**Re: Request for Council's Advice on SSD-77211717 – Edmondson Park Block 24  
Affordable Housing**

## Attachment A – Detailed comments

SOLDIERS PARADE INTERFACE

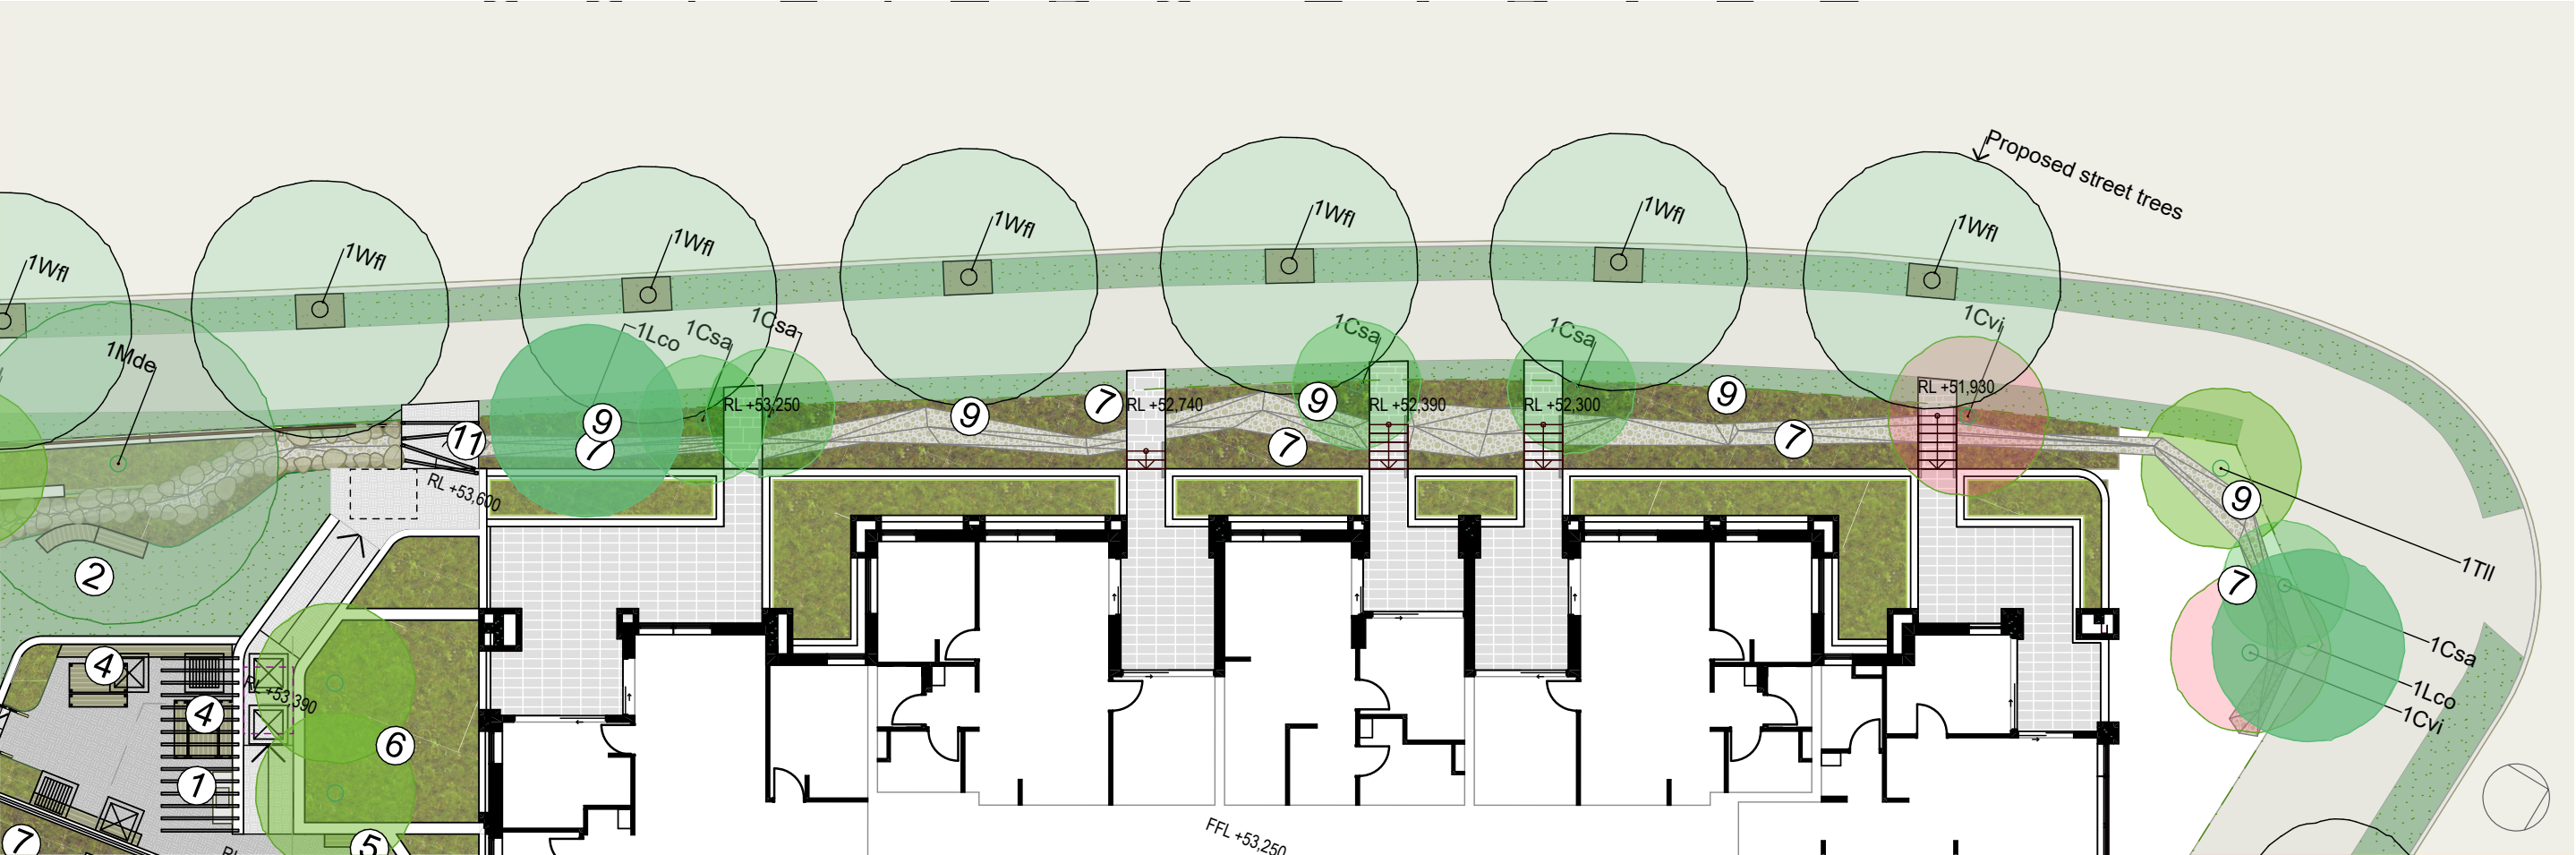
CDPD notes that the indicative planting verge of 1.2m shown in the cross-sections of the Architectural Design Report (Annexure J, page 35) is narrower than the verge width illustrated in the Typical Collector Road Section of the Edmondson Park South DCP (Figure 9), and also narrower than the 2m minimum planting width recommended in Council's Tree Management Framework. The proponent must review the street layout design to ensure the verge provides adequate space to support healthy mature tree growth. For planting details, refer to Council's Tree Management Framework as a guidance. At a minimum, a 1.5m wide verge is preferred to support appropriate street tree growth.
